Our ref: HE551507-MMSJV-VSS-000-CO-ZH-0065

Monday 18 February 2019

### **A303 Sparkford to Ilchester Dualling scheme**

**Application for a material change to an accepted Development Consent Order to include new land within the scope of compulsory acquisition and remove land from the Order Land**

REV.	DATE	AMENDMENT DETAILS	ORIG	CHKD	APP'D
P01	16/07/18	DCO SUBMISSION	MH	CS	ER

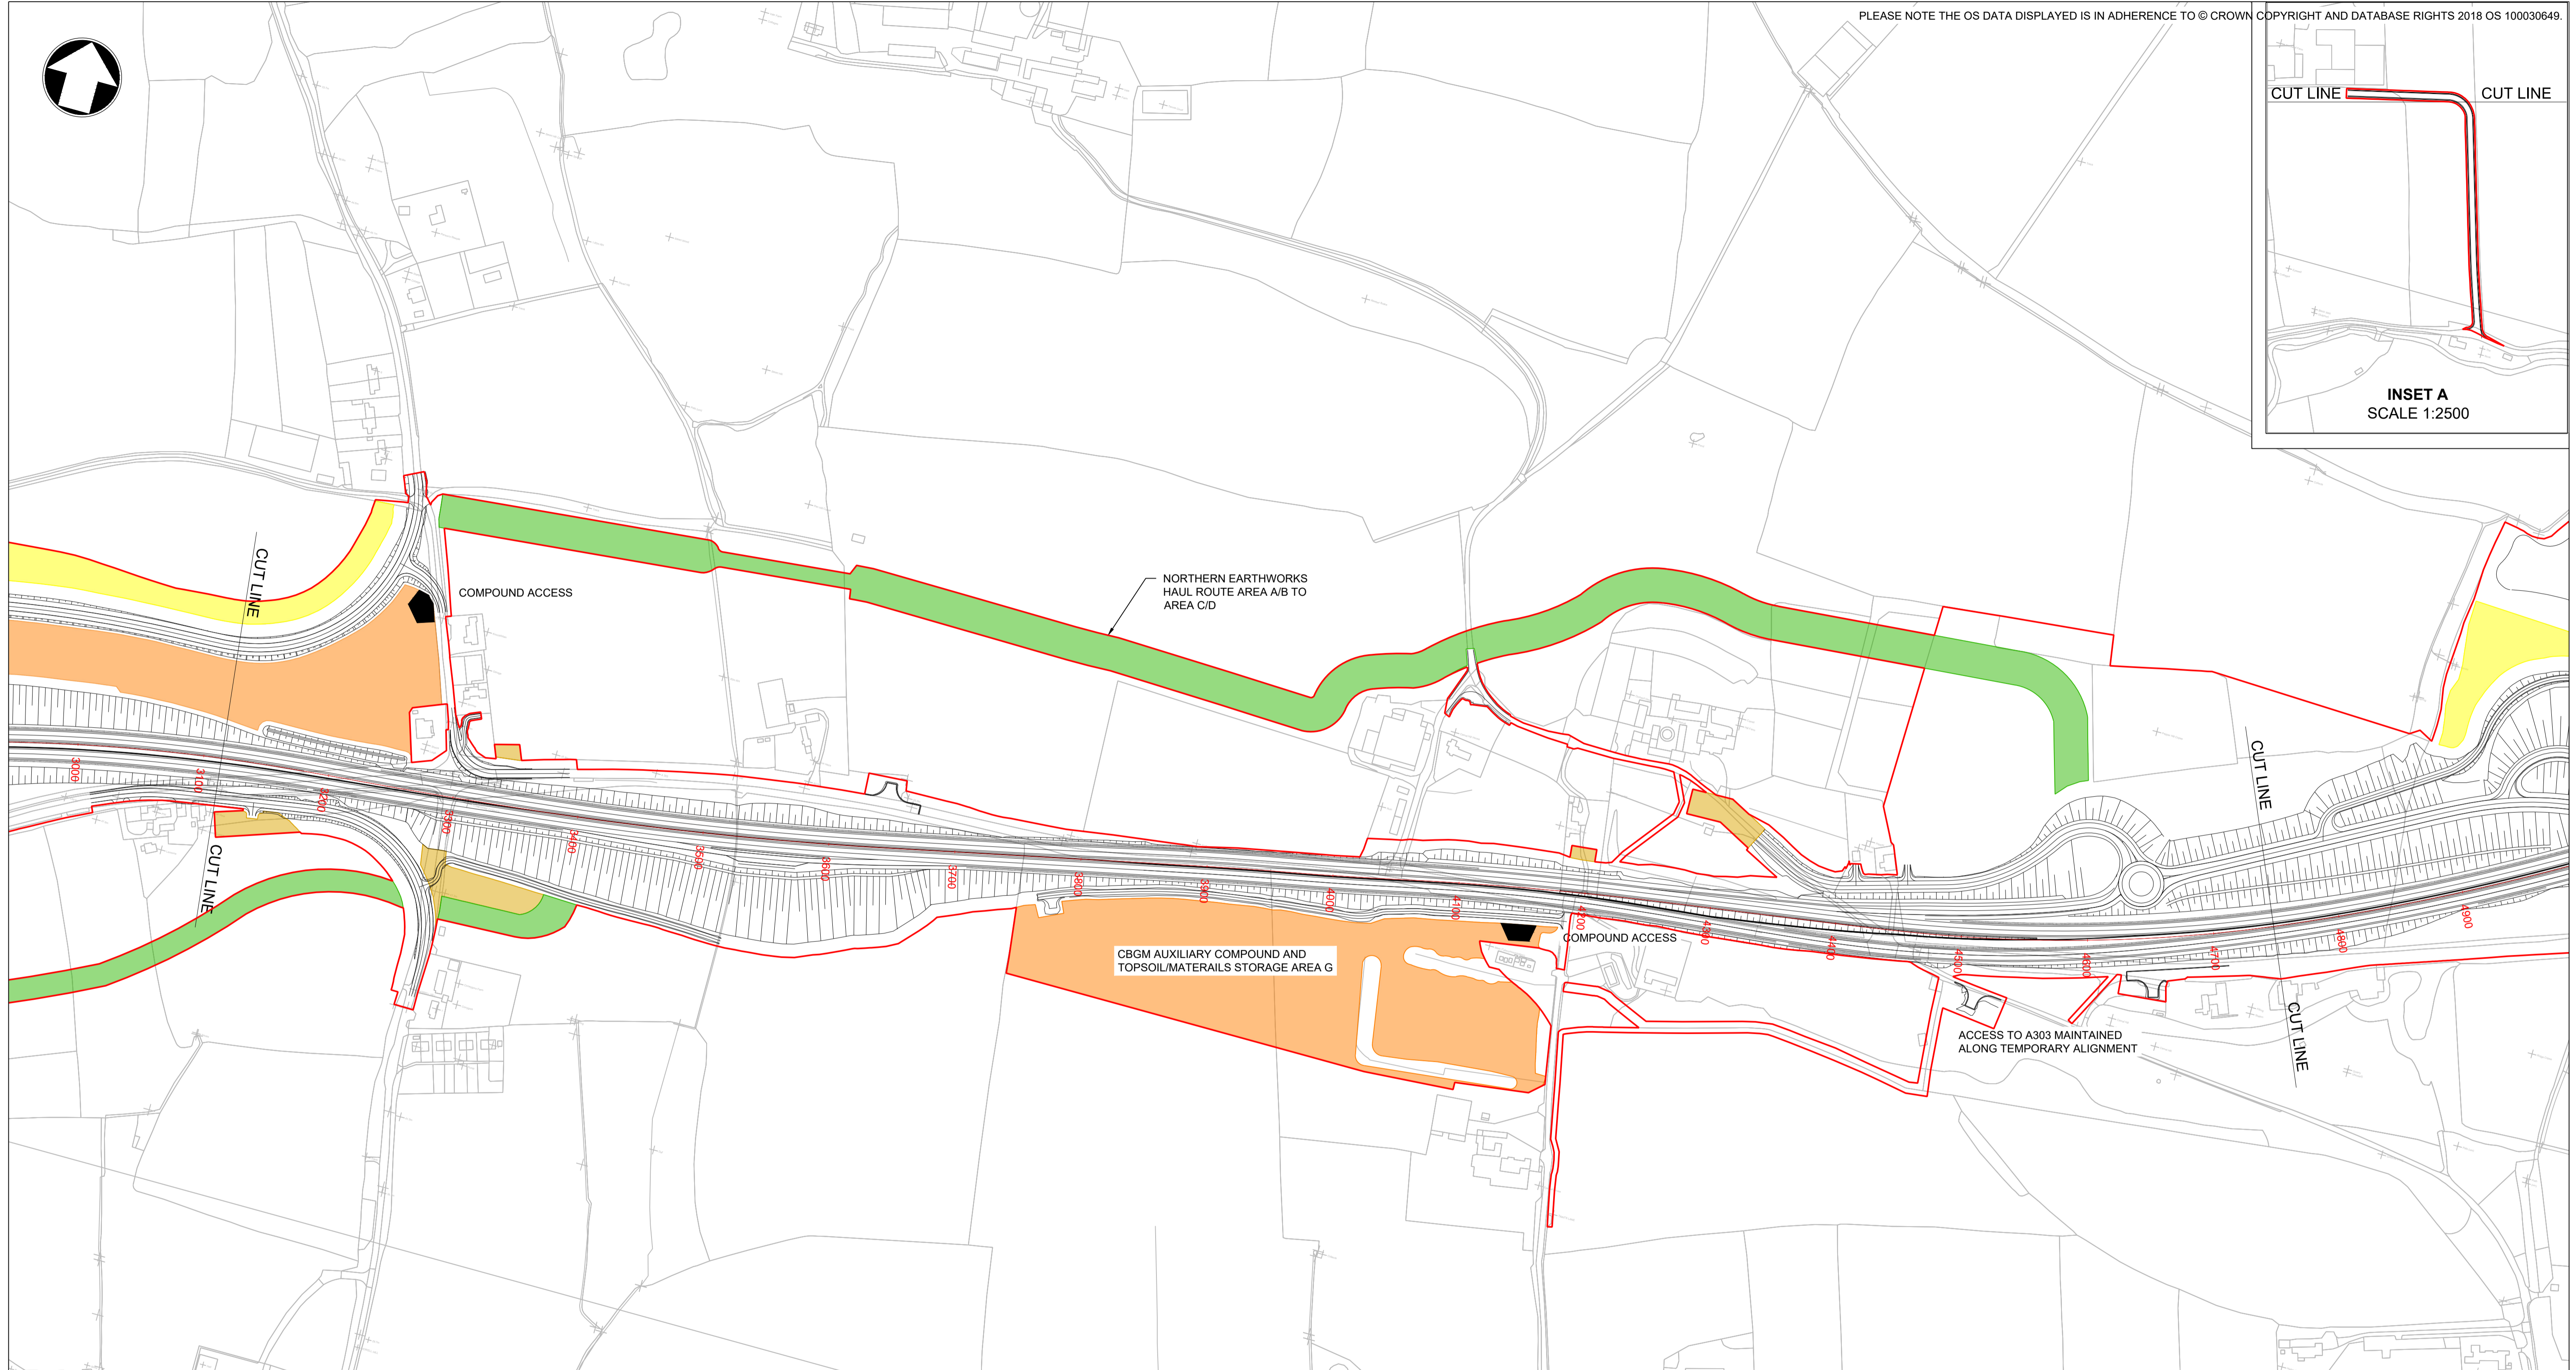
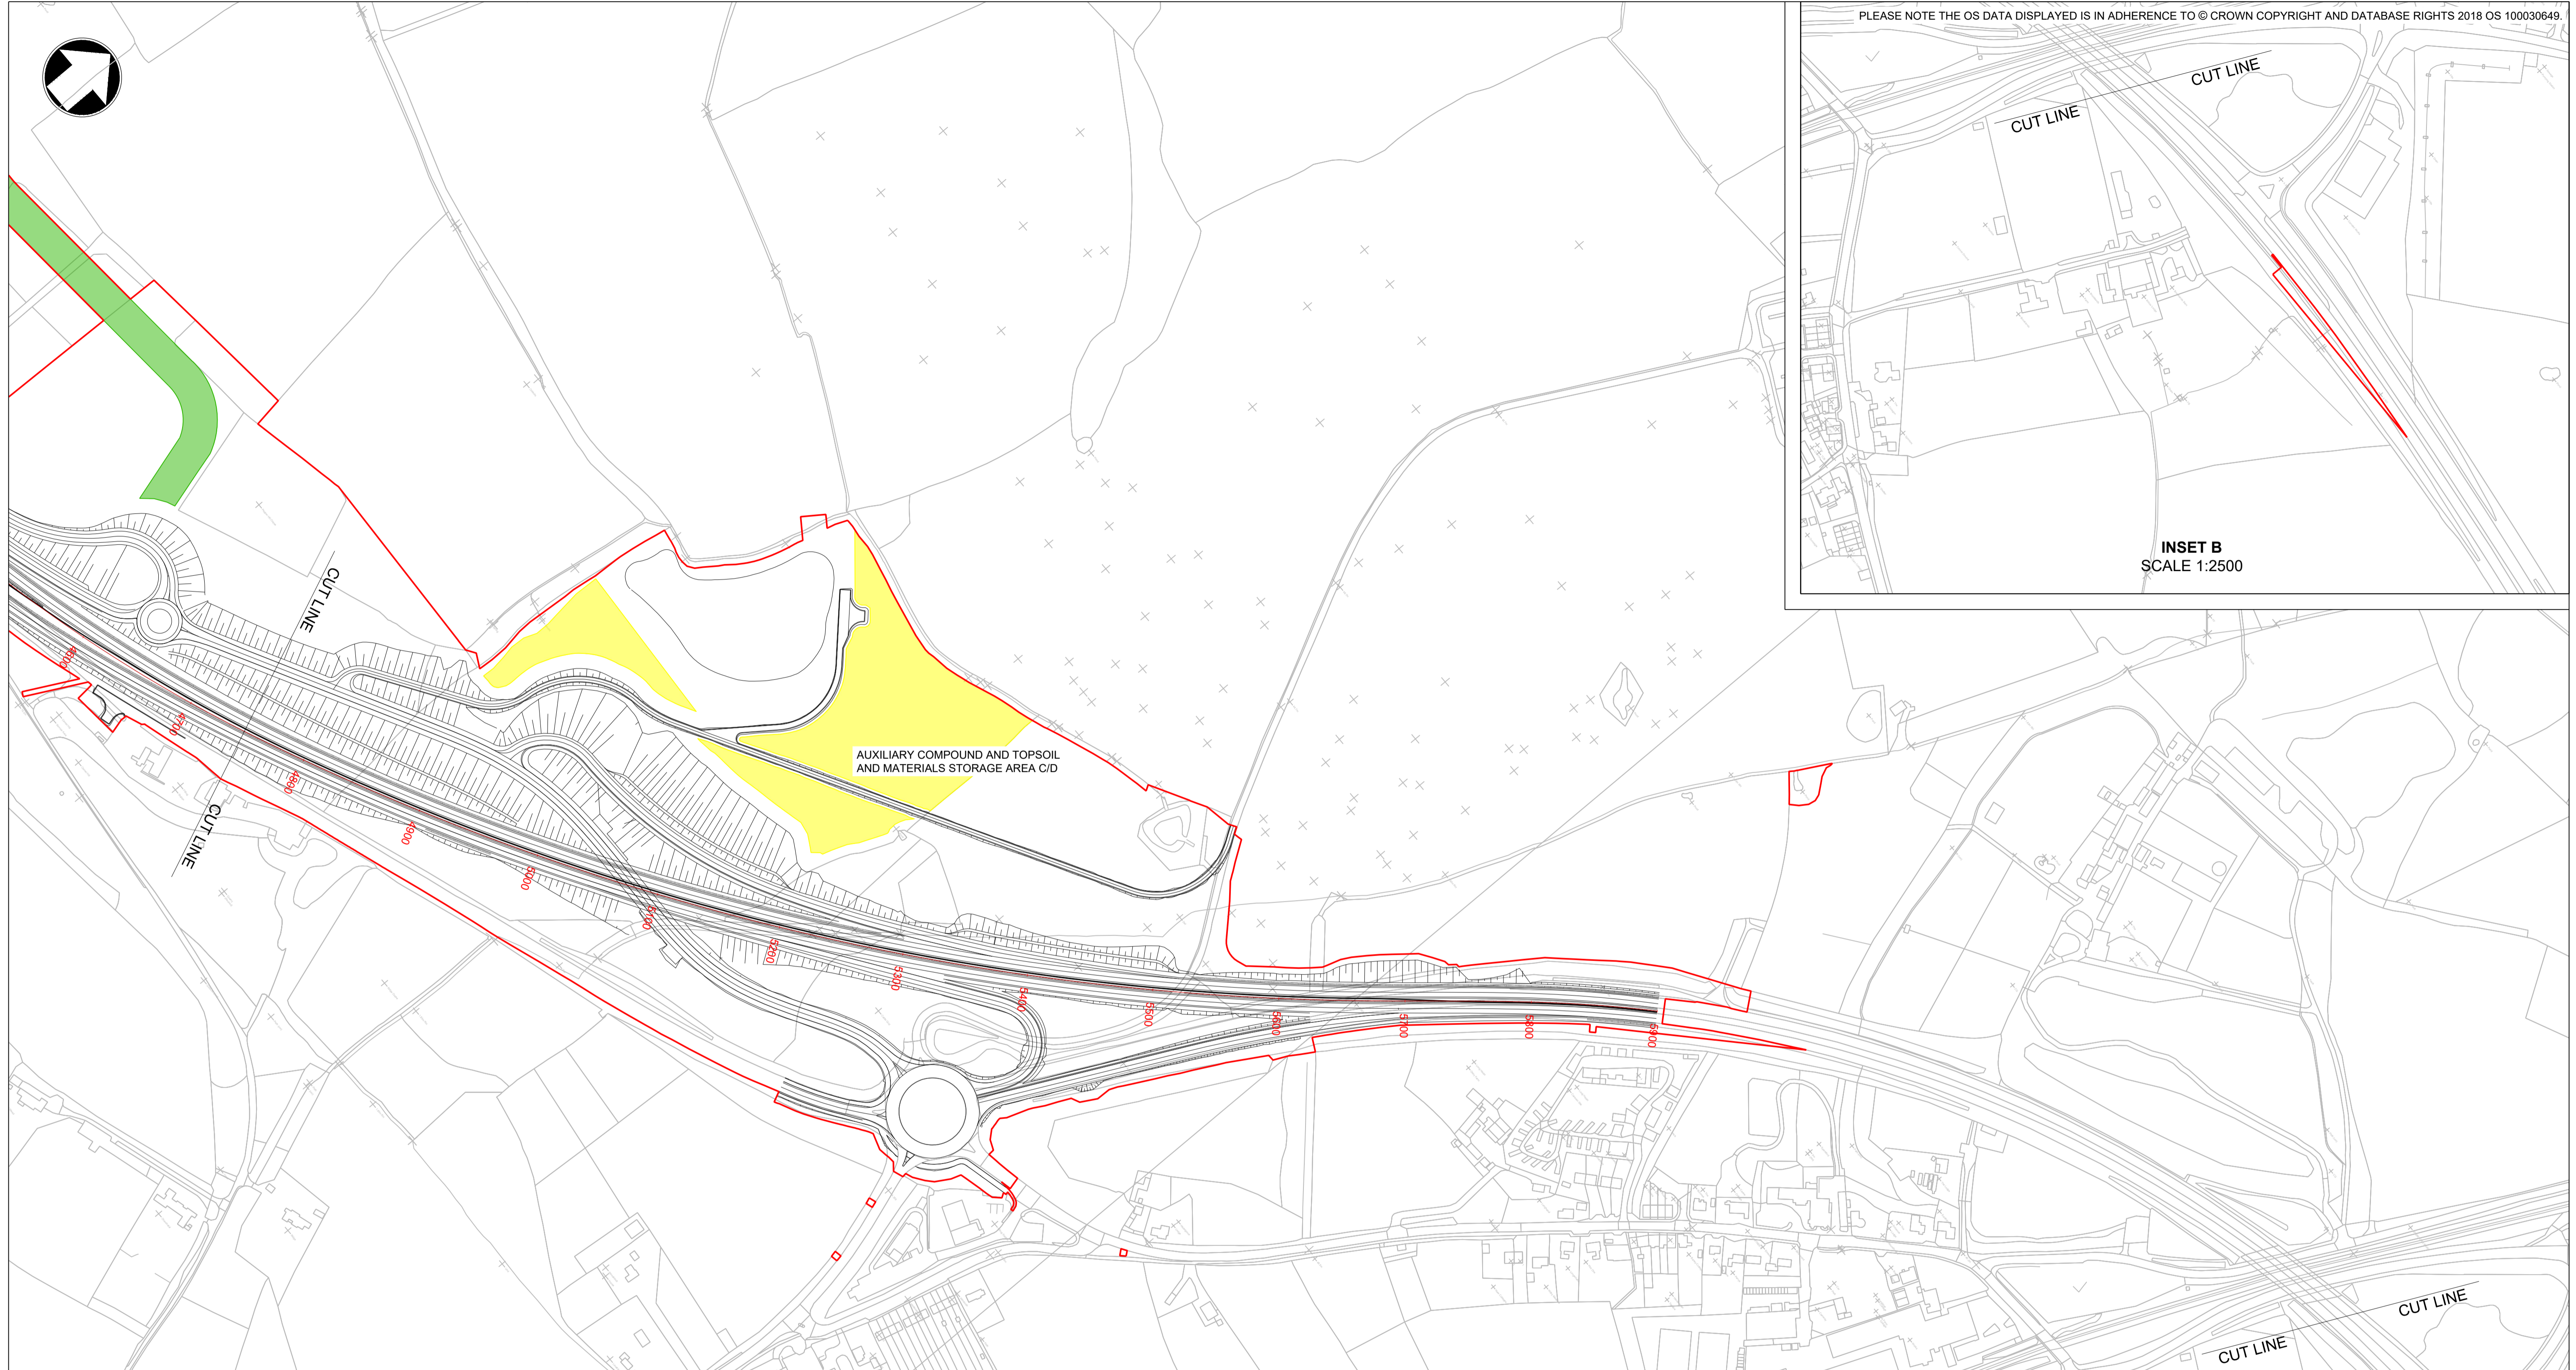
- An amendment to the layout, siting and size of the main construction compound which requires additional land to be added to the land affected by the DCO and which would allow the removal of some of the land currently affected.

- The addition of 98,589 square metres of agricultural land lying to the south of the A303, and the north of the B3151 and marked as plot 2/5e.

- The removal of 47,095 square metres of agricultural land lying to the south of the A303, and the north of the B3151 previously forming part of plot 2/5b, which lies to the immediate east of the land shown as plot 2/5e on the map and to the south of the remaining section of plot 2/5b.

- 2.1 Highways England has been informed by the Defence Infrastructure Organisation (DIO) that much of the land currently identified as the main construction compound is required by them for the installation of new landing lights. Highways England were not aware of the timing or impact of this proposal during pre-application consultation and the conflict of proposed uses has only become apparent following submission of the DCO application.

- 2.2 Highways England have been in correspondence with DIO and have been informed that the proposed landing light works will be carried out between April 2019 and March 2020 and that co-use of the area required for those works is not acceptable to DIO. They advise that for safety reasons they will not agree to any other party working in or moving equipment about near the lights. Given this, Highways England have identified land immediately adjacent to the existing proposed compound area, within the same landownership which it considers is suitable for use as the replacement main construction compound. Highways England therefore requests a change to the red line of the Order to include a new construction compound area at plot 2/5e and to remove part of the existing compound area subject to retention of a strip on the northern edge to provide access creating a reduced plot 2/5b.

- 2.5 The larger size of the proposed new main compound allows the removal of much of plots 5/13b and 7/1b from compulsory acquisition. This area was previously proposed as a secondary construction compound; that has now been amalgamated with the main compound. This change will also assist in addressing objections raised by the landowner of 5/13b and 7/1b that these works would negatively impact on their agricultural operation and use of their unaffected land.
